Our ref: P01426749  
25 May 2021

**LAND AT FORMER RAF BICESTER, BICESTER, OXFORDSHIRE, OX26 5HA  
Application No. 21/01224/OUT**

**Historic England Advice**

Figure 45. Proposed Automotive Demonstration And Driver Experience Diagram (not to scale)

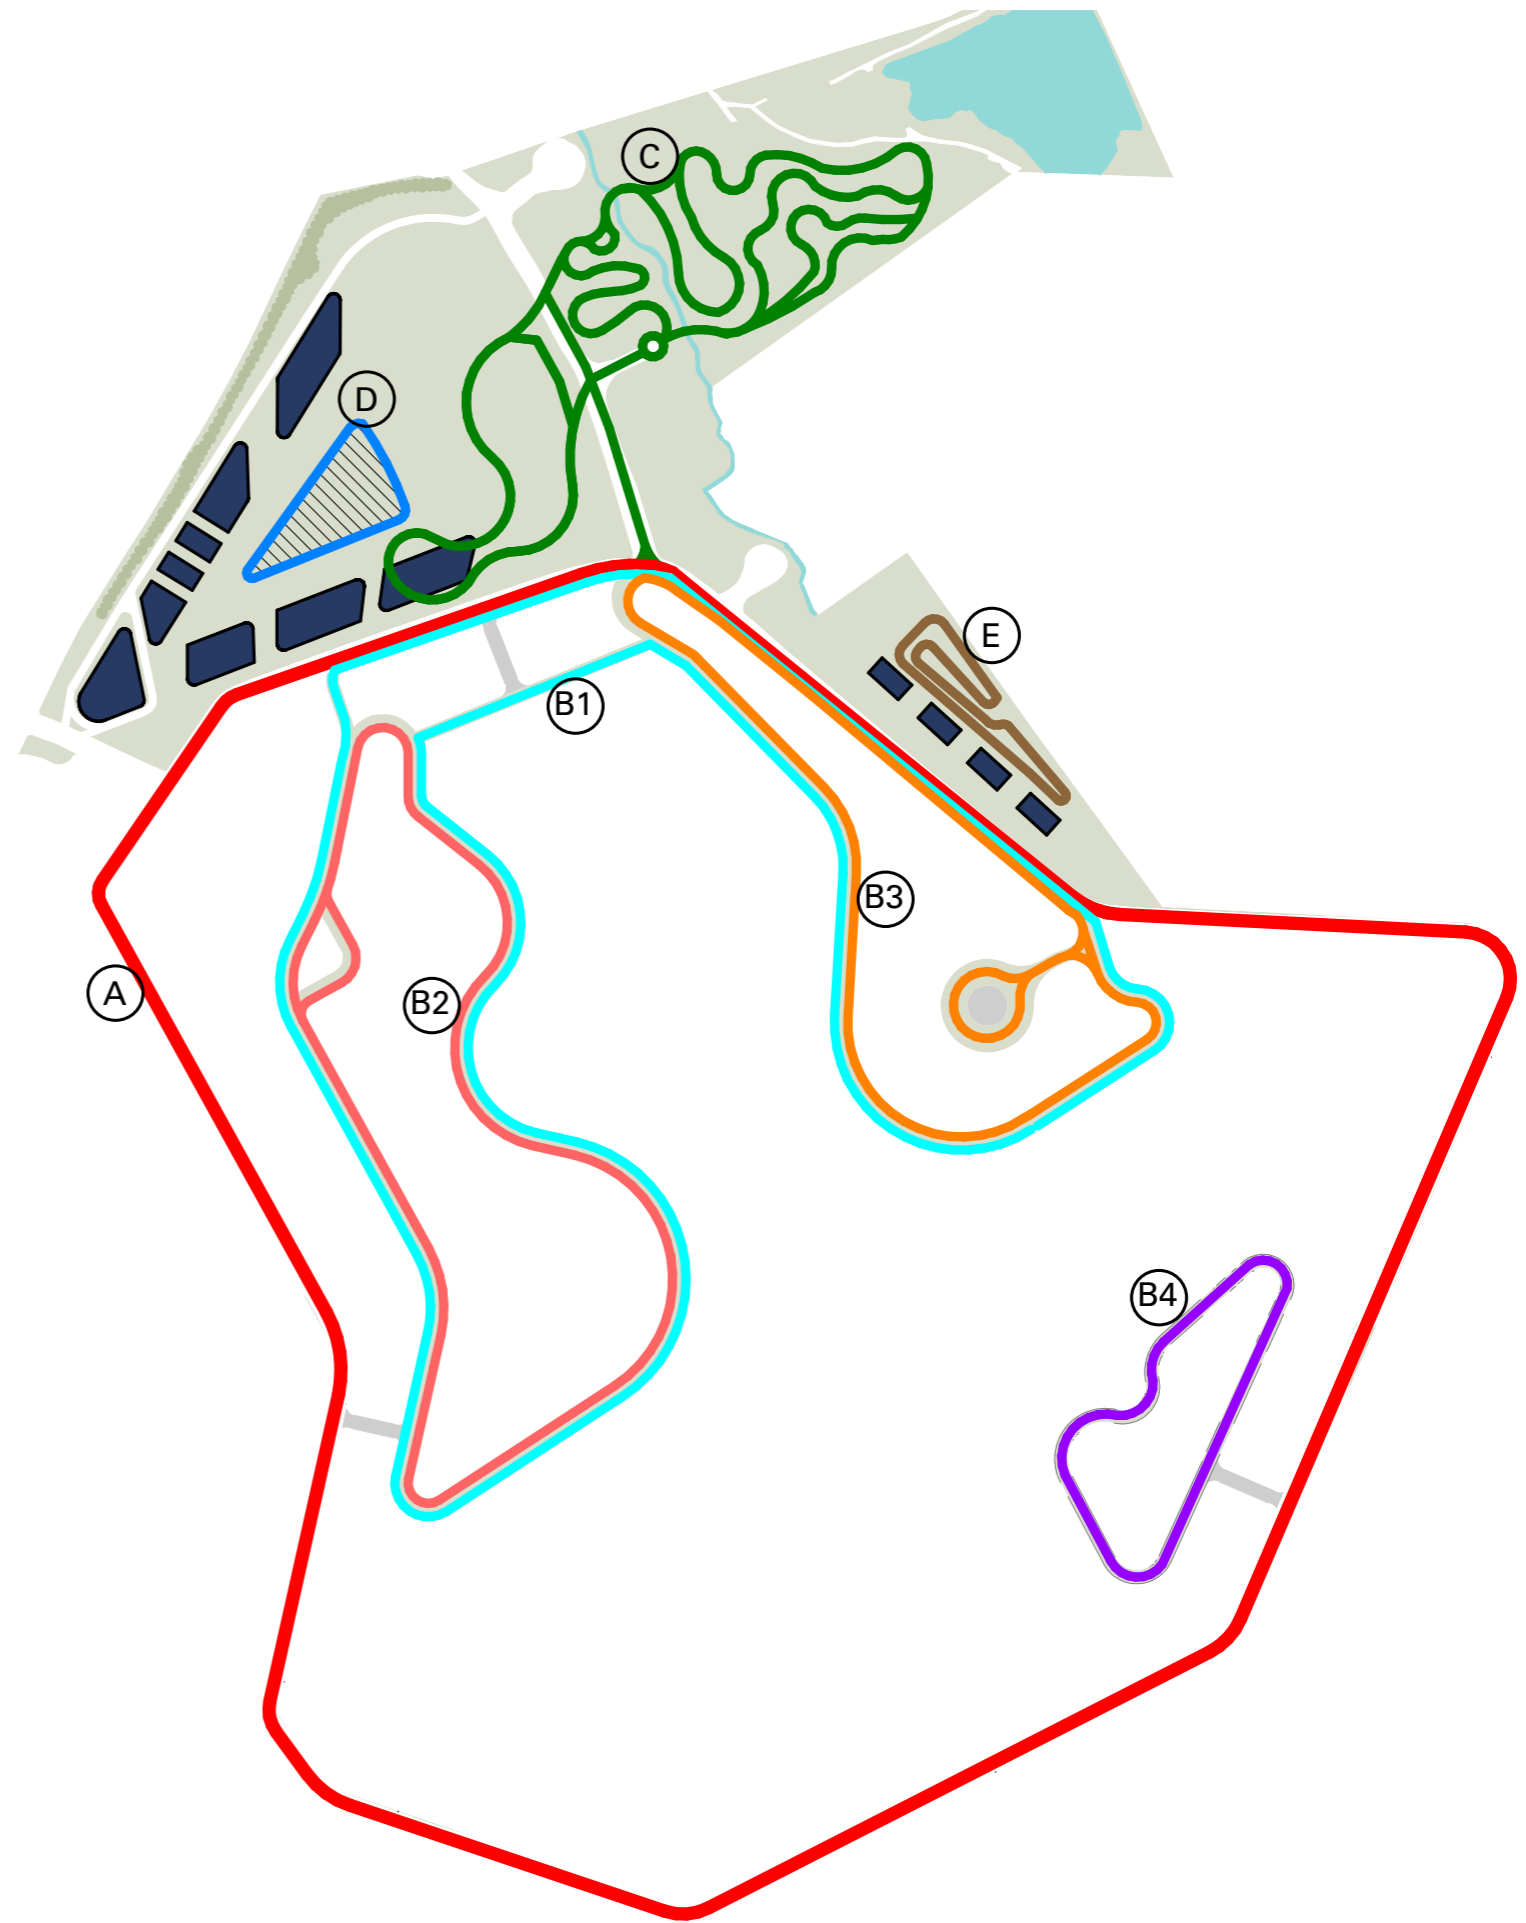
This outline application proposes an Experience Quarter with car galleries, demonstration circuits, and viewing pavilions. As presented in the indicative plans and Design Code, the scale and nature of the proposals would irrevocably change that 'stepping back in time' quality, and cause demonstrable harm to the conservation area and setting of statutorily protected structures and buildings within the former RAF base, in particular the grade II listed viewing tower which has a particularly close relationship with the flying field. This harm would occur in the following ways:

- 3) Finally, the bombers would taxi to and from the panhandles to the runway on the perimeter track with the wheels on the track and the large wings greatly overhanging this. If the perimeter track is altered by bunds or other upstanding barriers or features its original function becomes much more difficult to understand.

Figure 3. Parameters Plan - Proposed Developable Areas (not to scale)

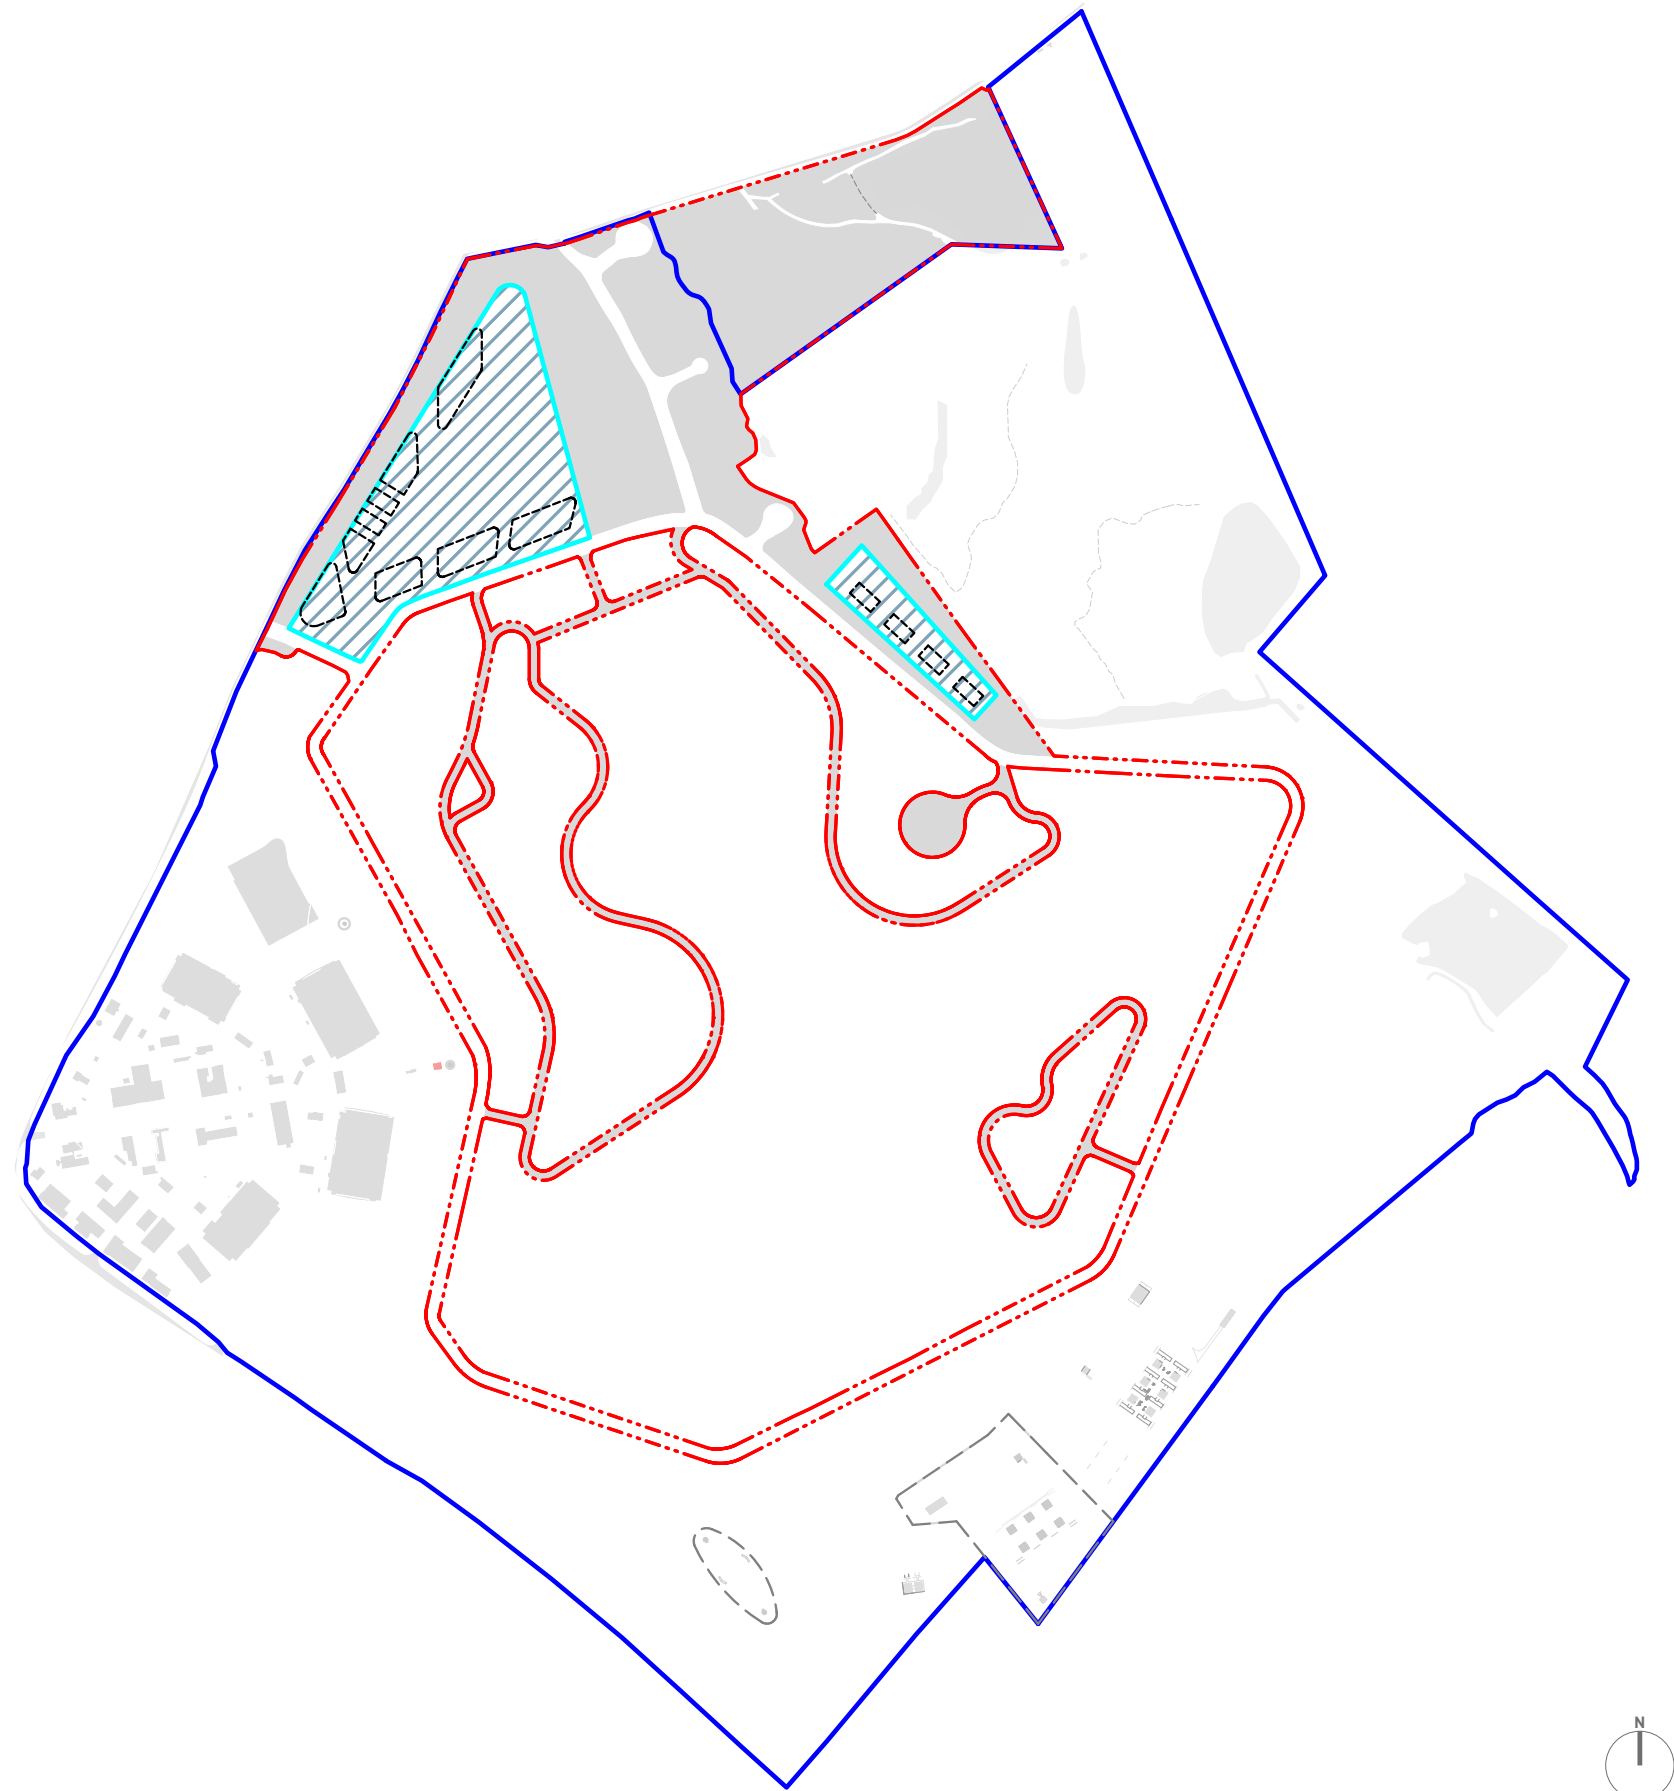
- 1) The development of the area to the north would remove the overrun area, which was an important safety feature at the base that allowed space for take offs to be aborted or landings to over-run. This area is defined as an integral part of the flying field Conservation Area Appraisal 2008 (Figure 12) and the Bicester Planning Brief 2009 (Fig 2).
- 2) The open and unencumbered character of the flying field is a key characteristic defined in the conservation area and building outside the perimeter track would seriously erode that. As well as contribution to the sense that RAF Bicester is a

time capsule, that visiting is the closest you can get to experiencing what it was like to be at an airbase during the 30s or the Second World War, this open nature helps explain how the site was used. Heavily laden bombers would need a clear approach to take off and land in, unencumbered by buildings. The isolated nature of the site not only reflected the dangerous nature of flying bombers, which meant that they were best kept way from centres of population, but also reflected the need to place these bases away from towns to make them more difficult for the enemy to find.
